DECISION DELEGATED TO HEAD OF PLANNING

Application No: H13-0459-25 **Applicant:** Moulton Windmill Project

Proposal: Proposed siting of photovoltaic panels on existing roof

Location: The Mill High Street Moulton

Front Elevation (SE)
Scale: 1:100

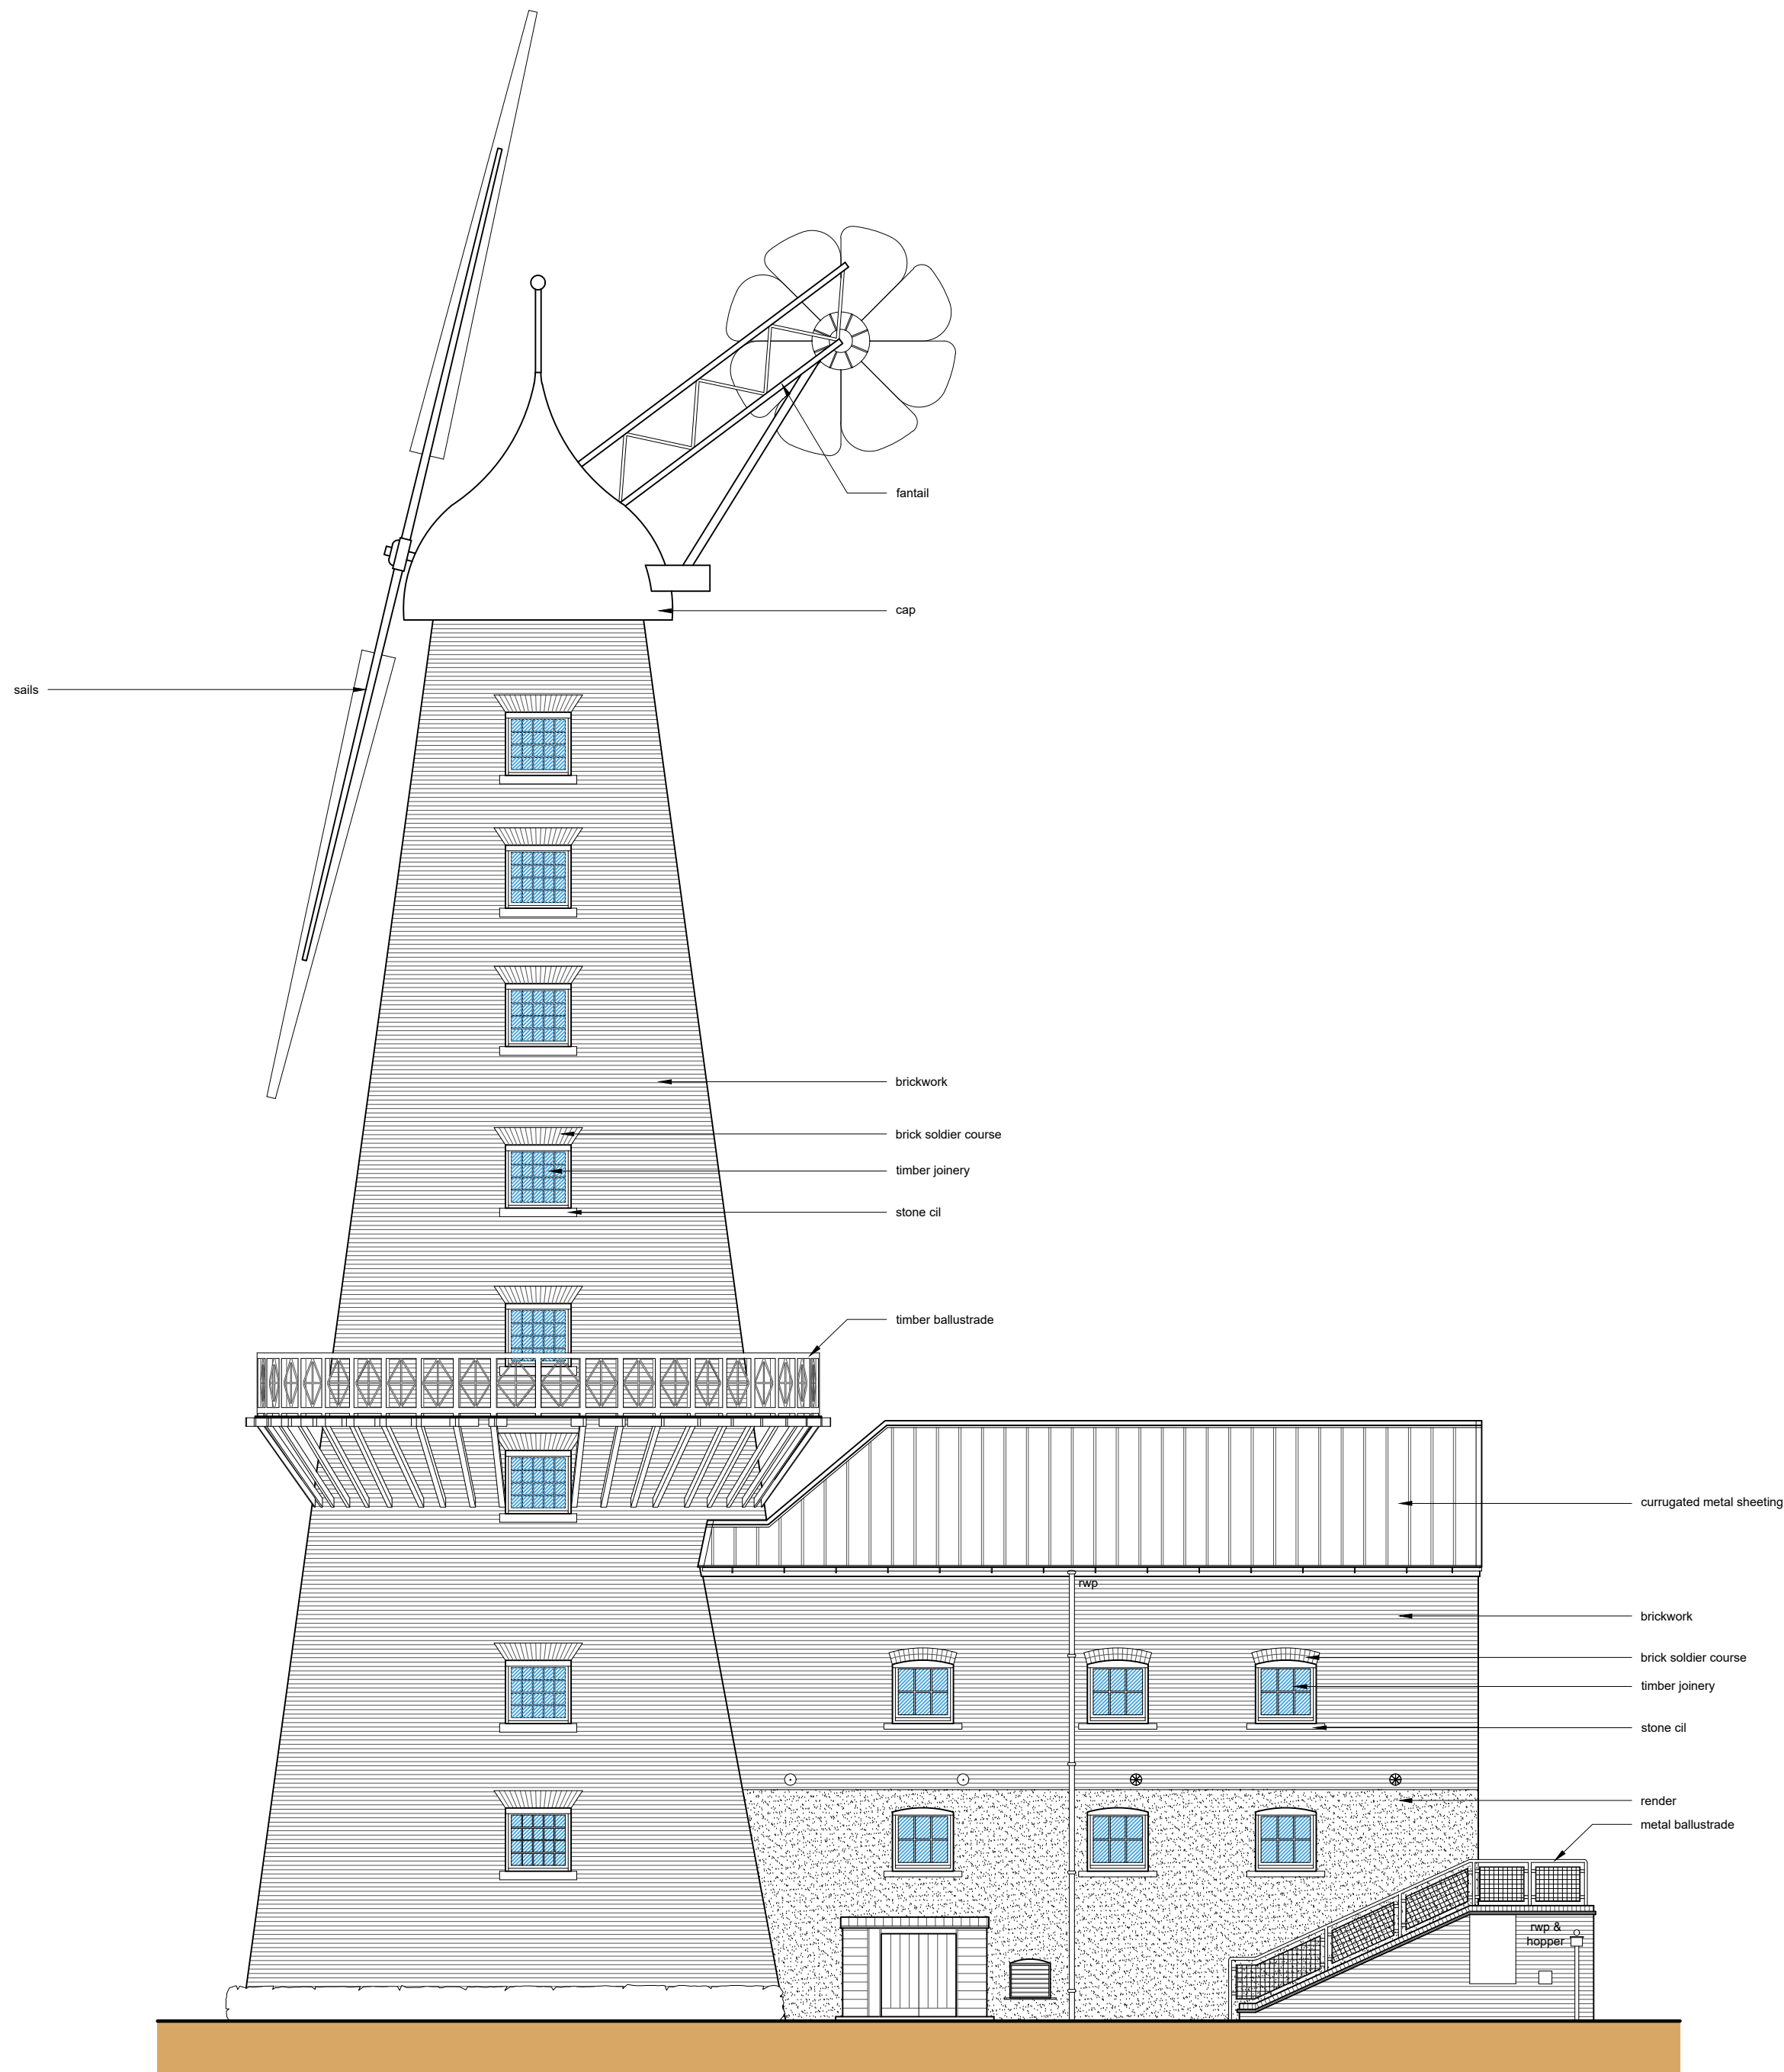
Concern that the proposed location of the photovoltaics on the south roof slope would look visually obtrusive and harmfully impact the significance of the Grade I listed mill and that of the Moulton

Suggest consideration is given of alternative ways to generate renewable energy, such as ground-mounted solar collectors, which would be less harmful to the significance of the Grade I listed mill.

Strongly recommend that the present application is withdrawn and that other less intrusive locations for solar panels are explored such as ground mounted solar collectors. Further advise the extent of the array proposed will also need to be carefully justified against its impact on the setting of the grade I listed building.

Consider that the proposal of fitting photovoltaic panels on the roof would negatively alter the appearance of the Grade I listed mill.

Advise If roof mounted panels are pursued, very strong justification is needed for alterations to a grade I listed building. An energy needs analysis should be provided that identifies the typical energy use on the site and the minimum number of panels needed to satisfy this use. It is considered there is no evidence to suggest the extent of panels proposed is needed to meet that demand (or indeed if it is enough) and potentially a more discrete row of panel may be suitable.

Moulton Mill is a Grade I listed building, is located within the Moulton Conservation Area, its significance lies in its architectural and historic interest. The proposal seeks listed building consent for the installation of solar panels on the south elevation of the former granary building, attached to the east of the windmill. Although the roof covering of the building is not original fabric, the existing metal covering is simple in form and does not detract from nor compete with the sublimity of the Windmill. In contrast, it is considered that the proposed solar panels, covering almost the entire roof slope, would have a stark and incongruous appearance which would harm the architectural and historic character of the Grade I listed building.

The proposal involves the installation of solar panels, a source of renewable energy which is also considered a public benefit, to which moderate weight is attached. However, the solar panels would create a stark and incongruous addition to the southern roof slope, which, when viewed in the context of historic character of the Grade I listed building such installation would adversely affect the architectural and historic character of Moulton Mill, to which significant weight is attached.
